DECISION DELEGATED TO HEAD OF PLANNING

Application No: H14-0871-25 **Applicant:** Mr & Mrs Butler
Proposal: Erection of stable and change of use from agricultural land to equestrian - retrospective
Location: Land Adj. 14 Mill Green Road Pinchbeck Spalding
Terminal Date: 19th December 2025

SHEET
Block Plan

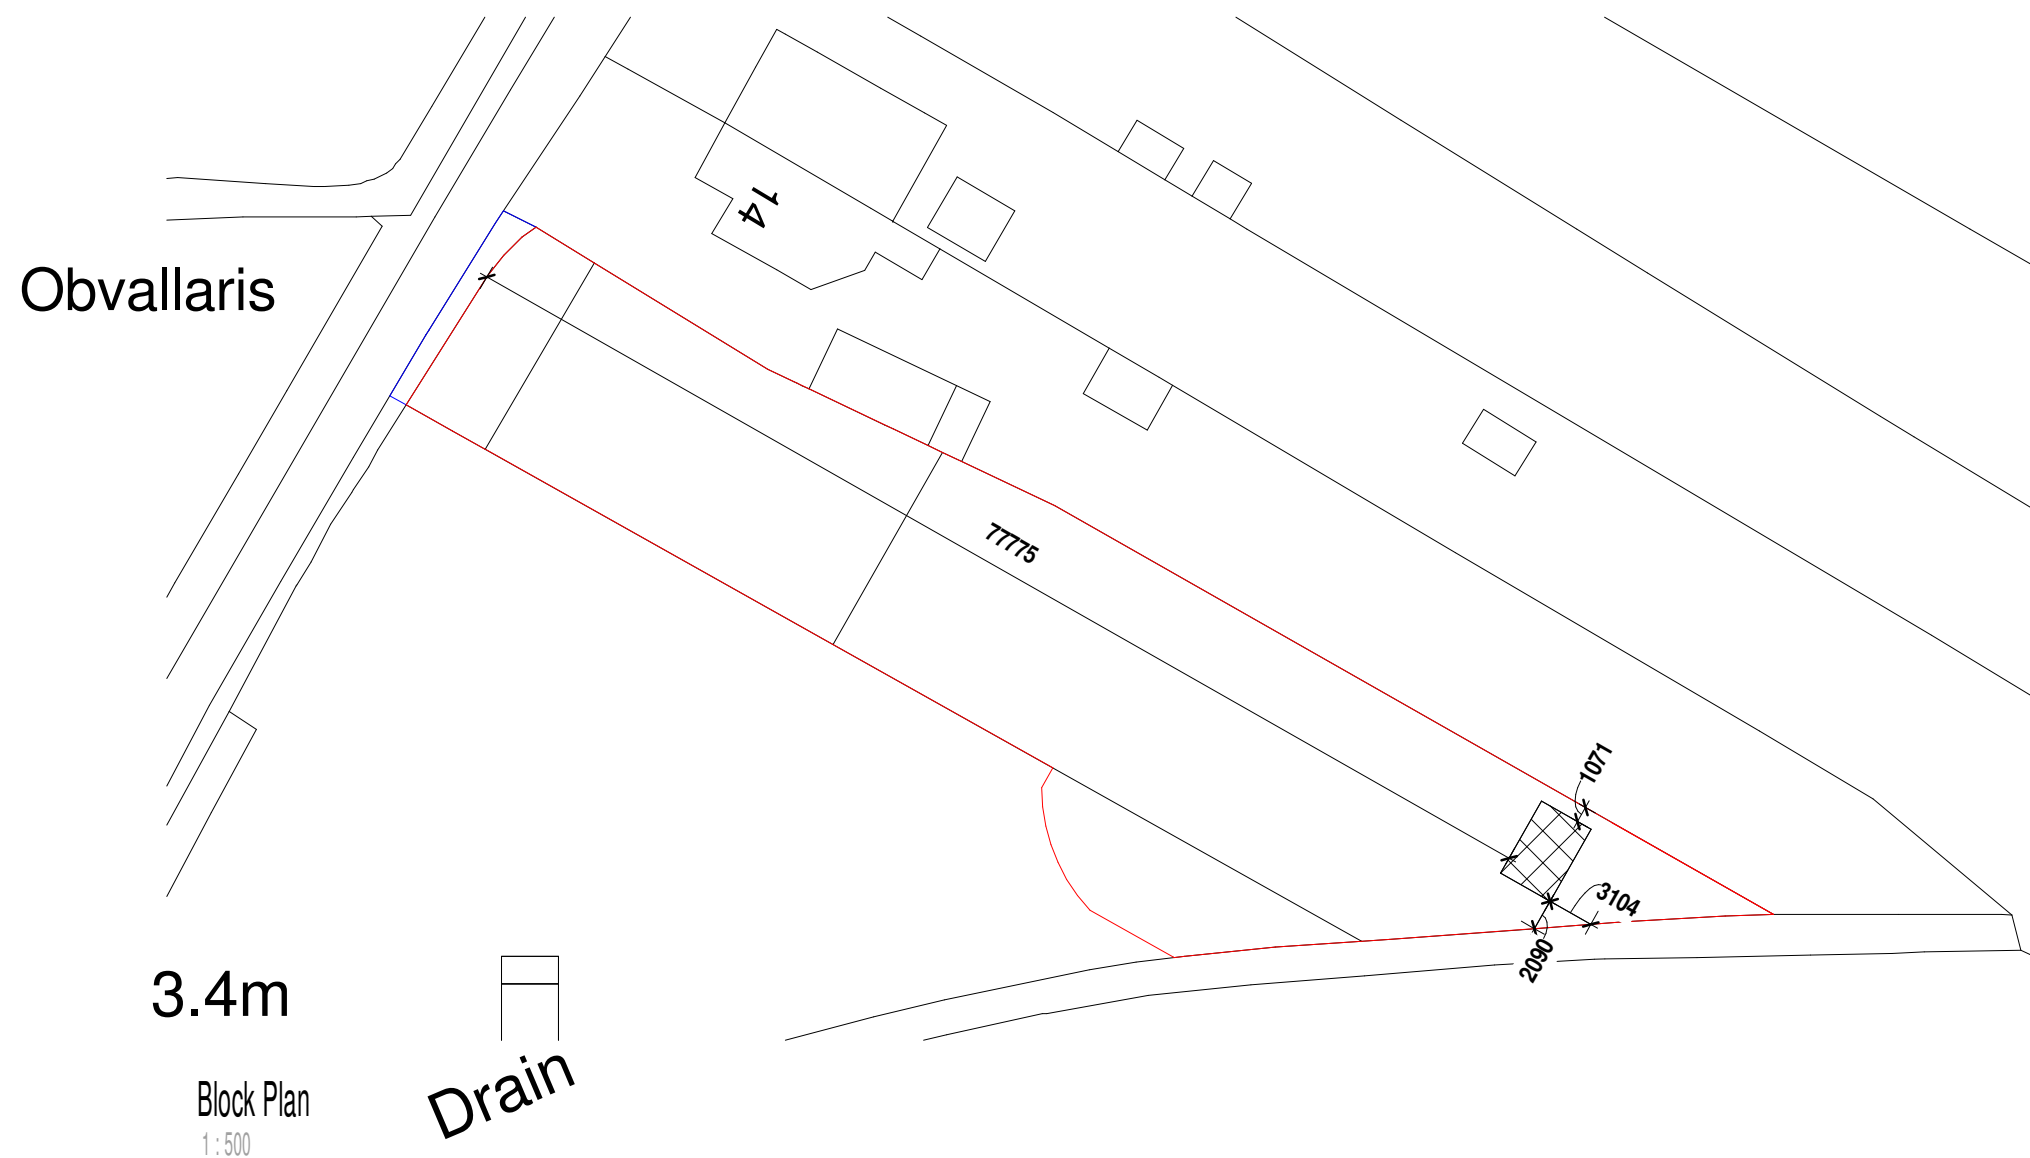
The access to the site is not formally constructed. A note should be added to the proposed site plan to say it will be upgraded to Lincolnshire County Council Specification.

The proposal is for the erection of stable and change of use from agricultural land to equestrian - retrospective. The access to the site is informal and needs upgrading the Lincolnshire County Council Specification - a condition is requested on the planning permission decision notice. The proposal will not have an adverse effect on the public highway. As Lead Local Flood Authority, Lincolnshire County Council is required to provide a statutory planning consultation response with regard to drainage and surface water flood risk on all Major applications. This application is classified as a Minor Application and it is therefore the duty of the Local Planning Authority to consider the surface water flood risk and drainage proposals for this planning application.

Within 6 weeks from the date of the decision notice the vehicular access to the site shall be improved in accordance with Lincolnshire County Council's Specification.
